Supplementary Plan pls. upload.

WA/7/19/RES - Lanes End, West Walberton Lane - Additional information request

PLOTS 1 AND 2 FLOOR PLANS AND ELEVATIONS

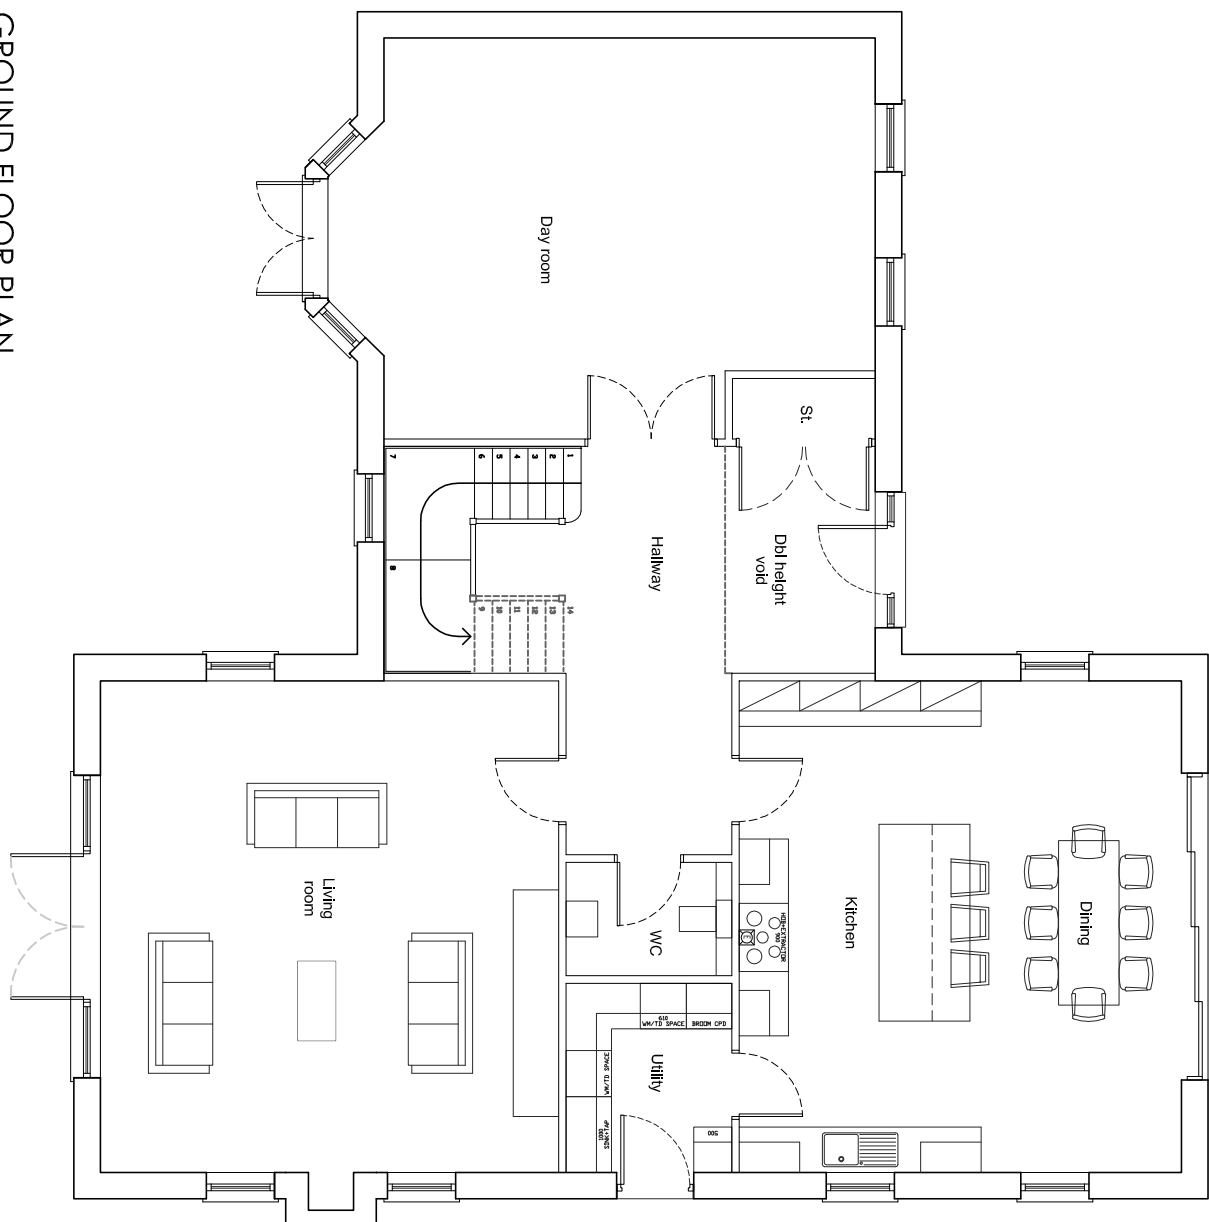
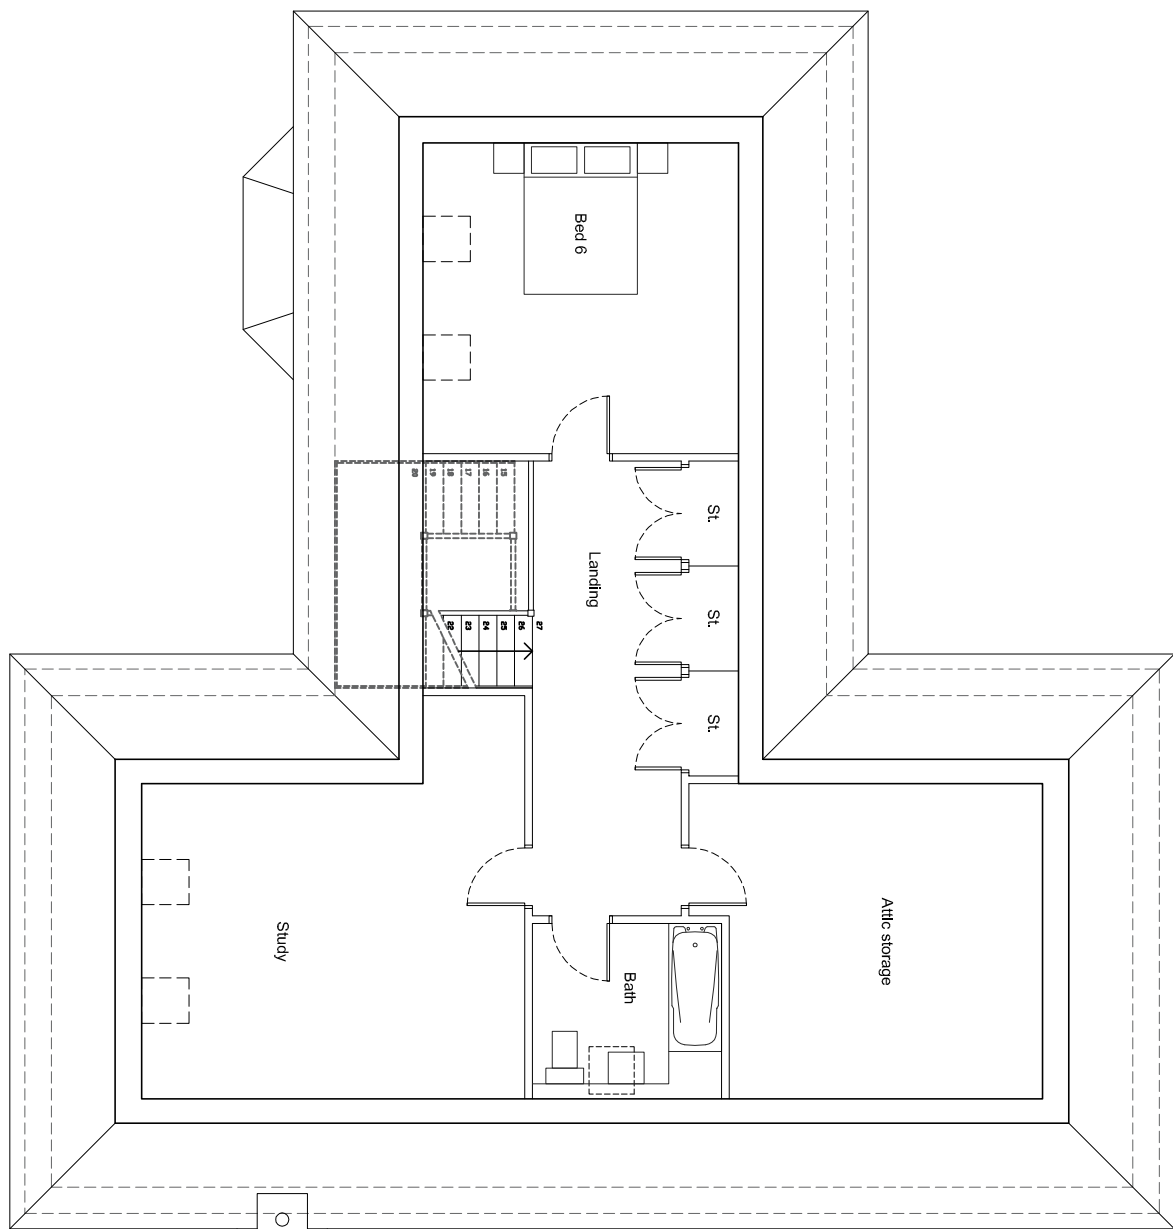
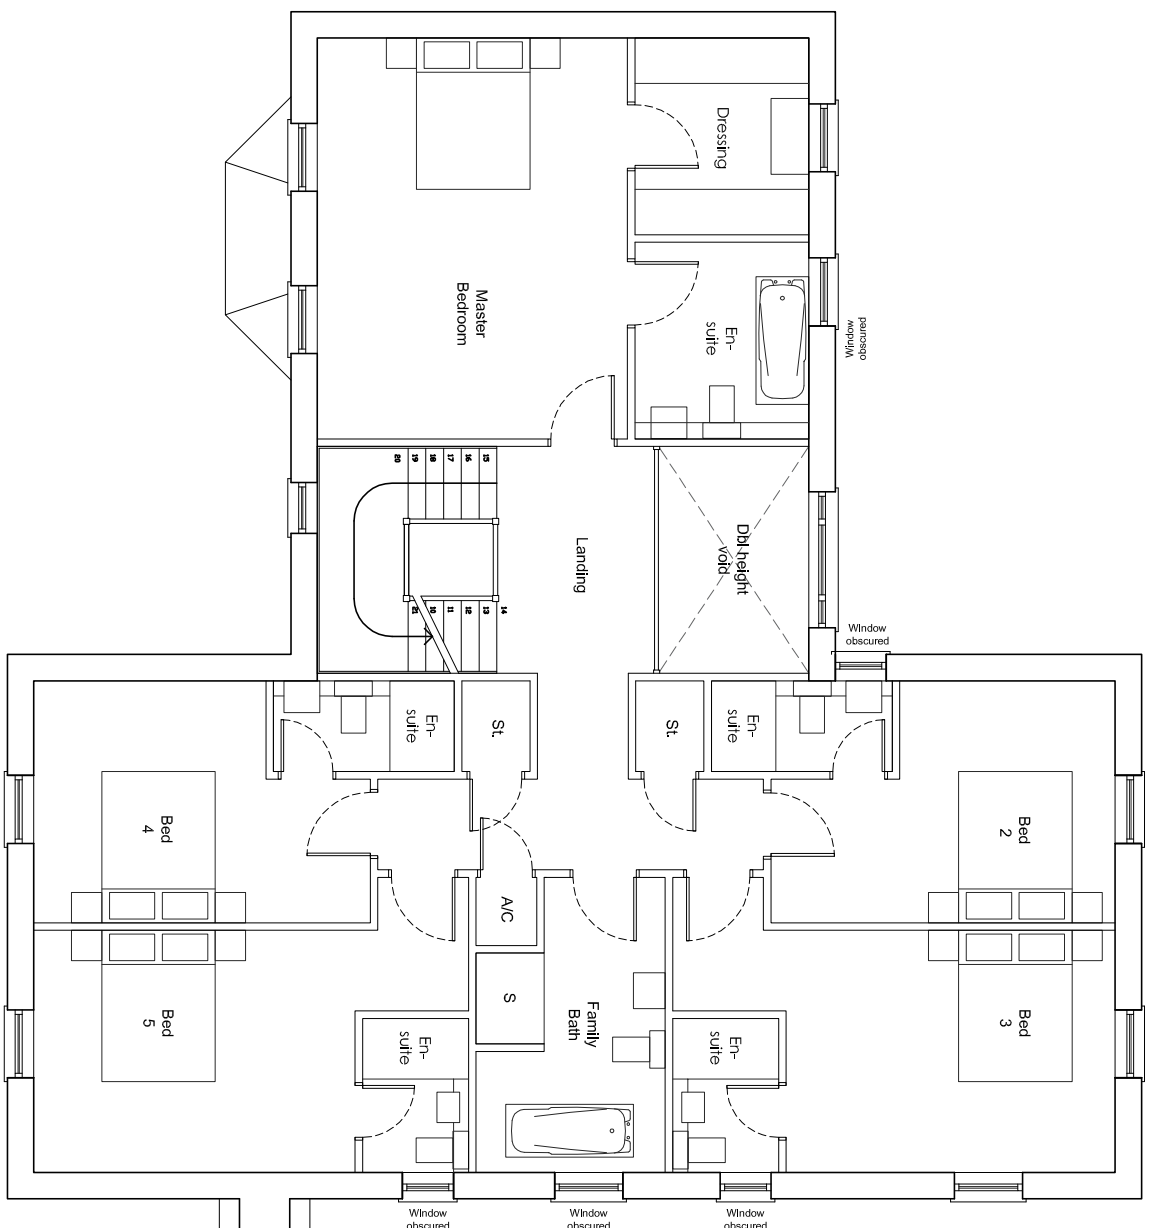
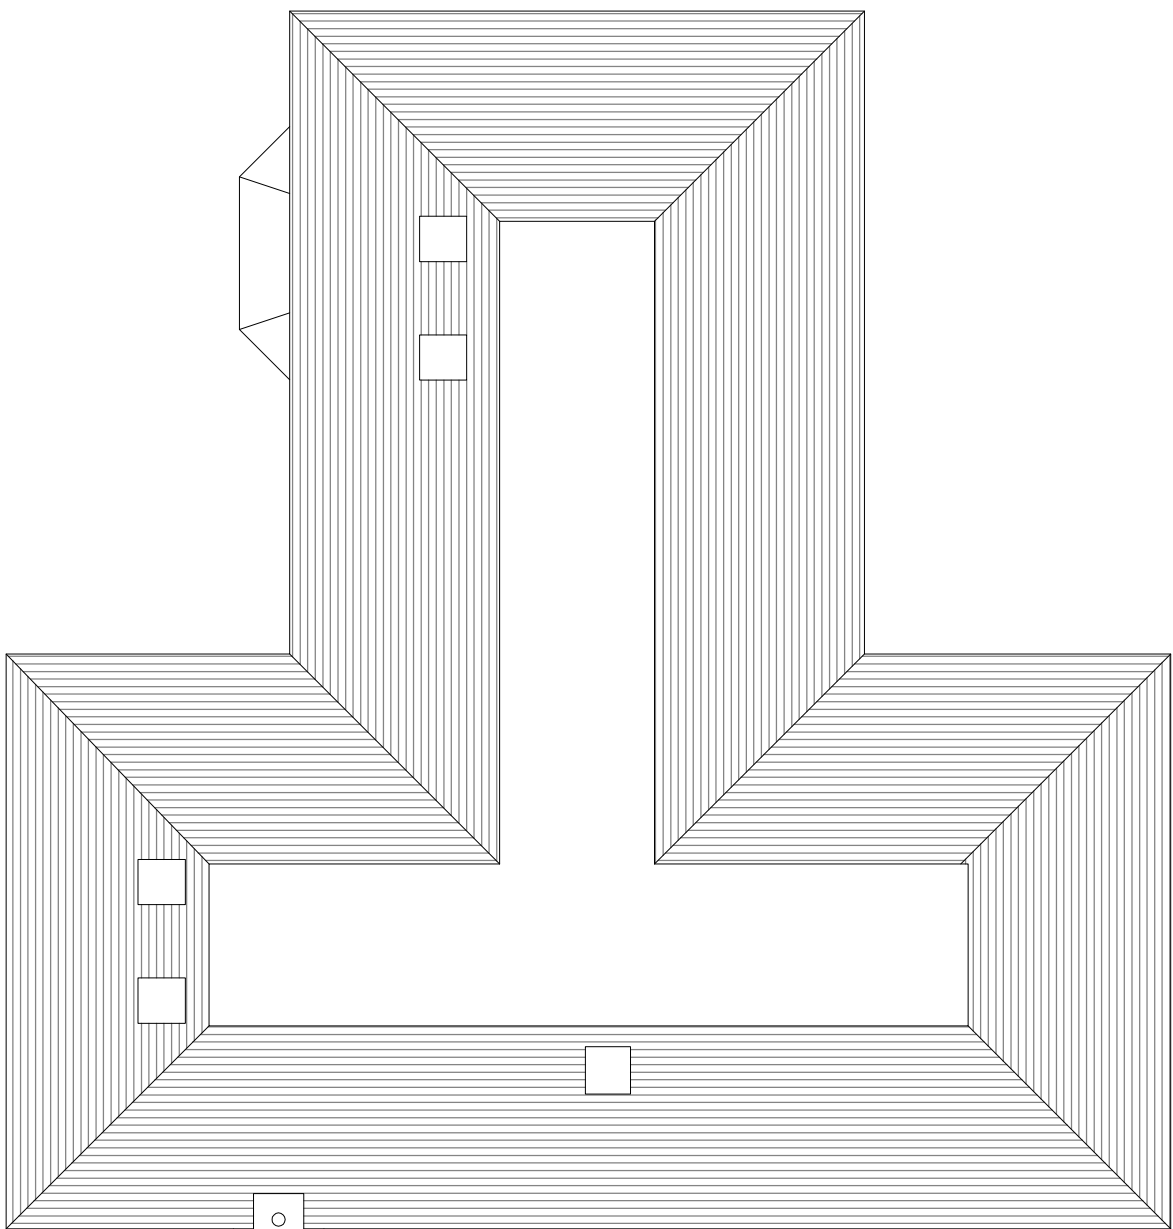
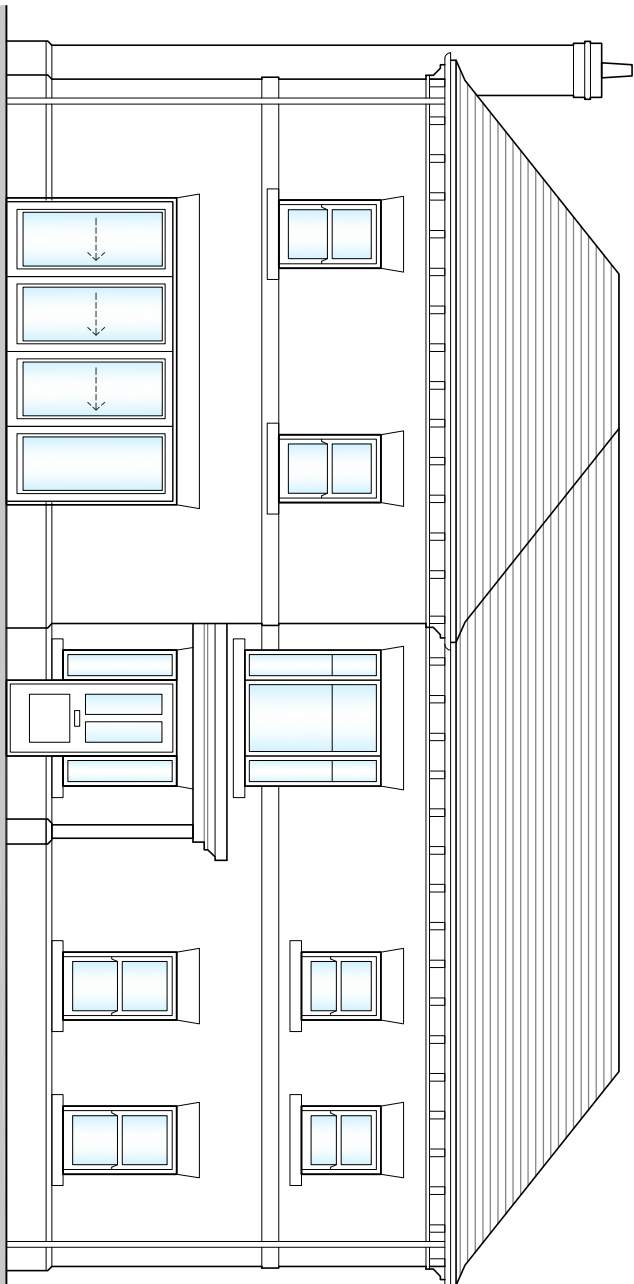
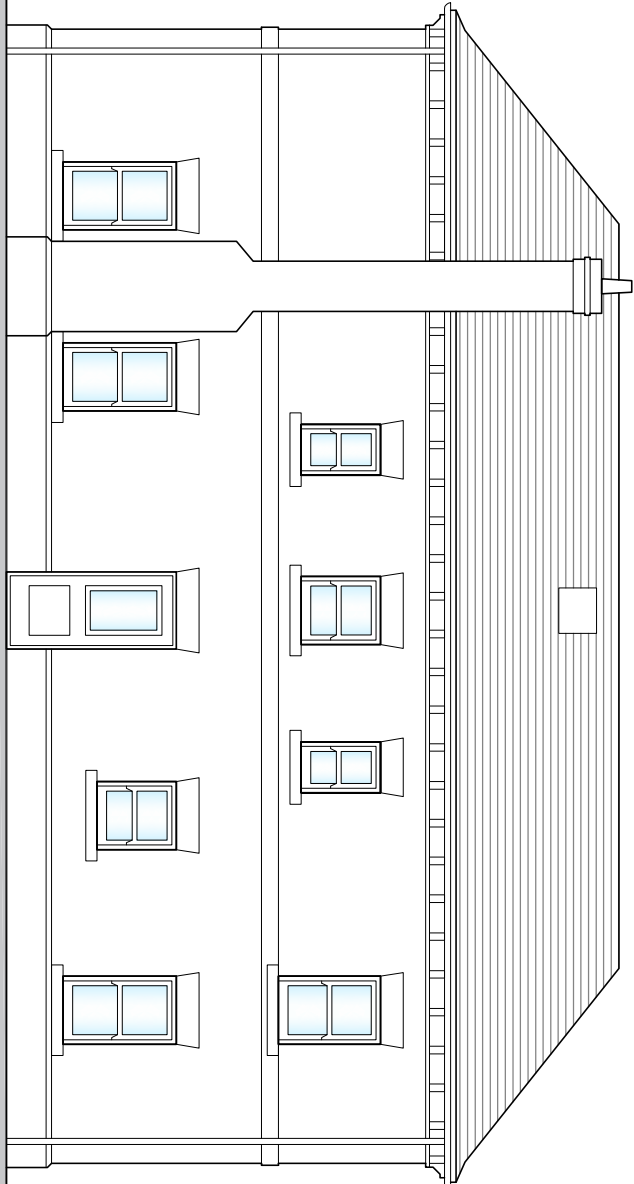
1. Amend the layout to ensure that a minimum of 9 metres exists on from blank gable end (or obscure glazed windows non opening below 1.7 metres in height) of nearest proposed house to gable end of 'Woodlands' which currently incorporates sole habitable room windows.
2. Remove second storey of houses/rooms in roof. 3 storey townhouses would not be acceptable in this location

2, we fail to see the merit in removing the room in the roof, this would have no impact on the height of the buildings and would result in empty lift spaces which would not allow for good use of space as per the NPPF. You will note from drawing 19-001-PL-03 all the dormers on houses 3-6 are in the south and therefore can not be seen from the front or any point outside the properties. Currently prosperities one and two have the dormers on the north but I would be happy to move these to the south so these are the same and none can be seen from Arundel road. I also would like to mention the design of white cottage next door that will have dormers in the roof and Richmond house which has velum windows in the roof. As previously mentioned the new ridge heights will be lower than the current house at Lanes end this can be seen in the scale drawings provided. If you could let me know if this is acceptable as if possible to avoid I would prefer not to have to appeal the reserved matters for this small item.
